From: Simon Davis
Sent: 07 February 2022 10:57

Subject: Y/7/22/PL Land adjacent to Bonhams & Flints

We have received ecology comments and these state:

Figure 3. Ponds within 500m of the site (MagicMap, 2021).

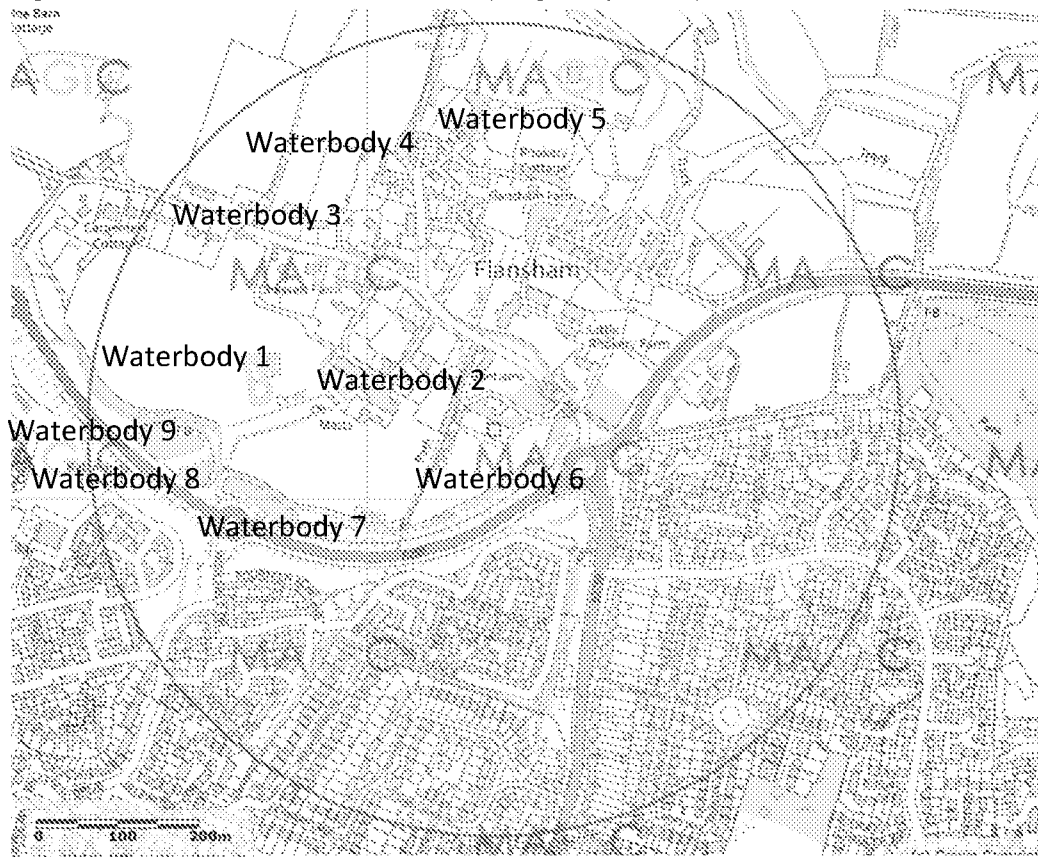
As detailed within the Ecological Survey (Nov 2021) further Great Crested Newt surveys are required in water body 6 and 7 in the form of eDNA assessments. If Great Crested Newts are found to be present further survey work would be required. We require that these surveys are undertaken prior to determination and submitted as part of this application.

As detailed within the Ecological Survey (Nov 2021) there is potential for Great Crested Newts to be using the terrestrial habitat onsite. Due to this and as recommended within the survey a further eDNA sampling survey is required on both ponds. The results of these surveys can then be used to create a suitable mitigation strategy and inform a Natural England protected species license if required. We require that these surveys are undertaken and the report and the mitigation strategy submitted with the planning application prior to determination.
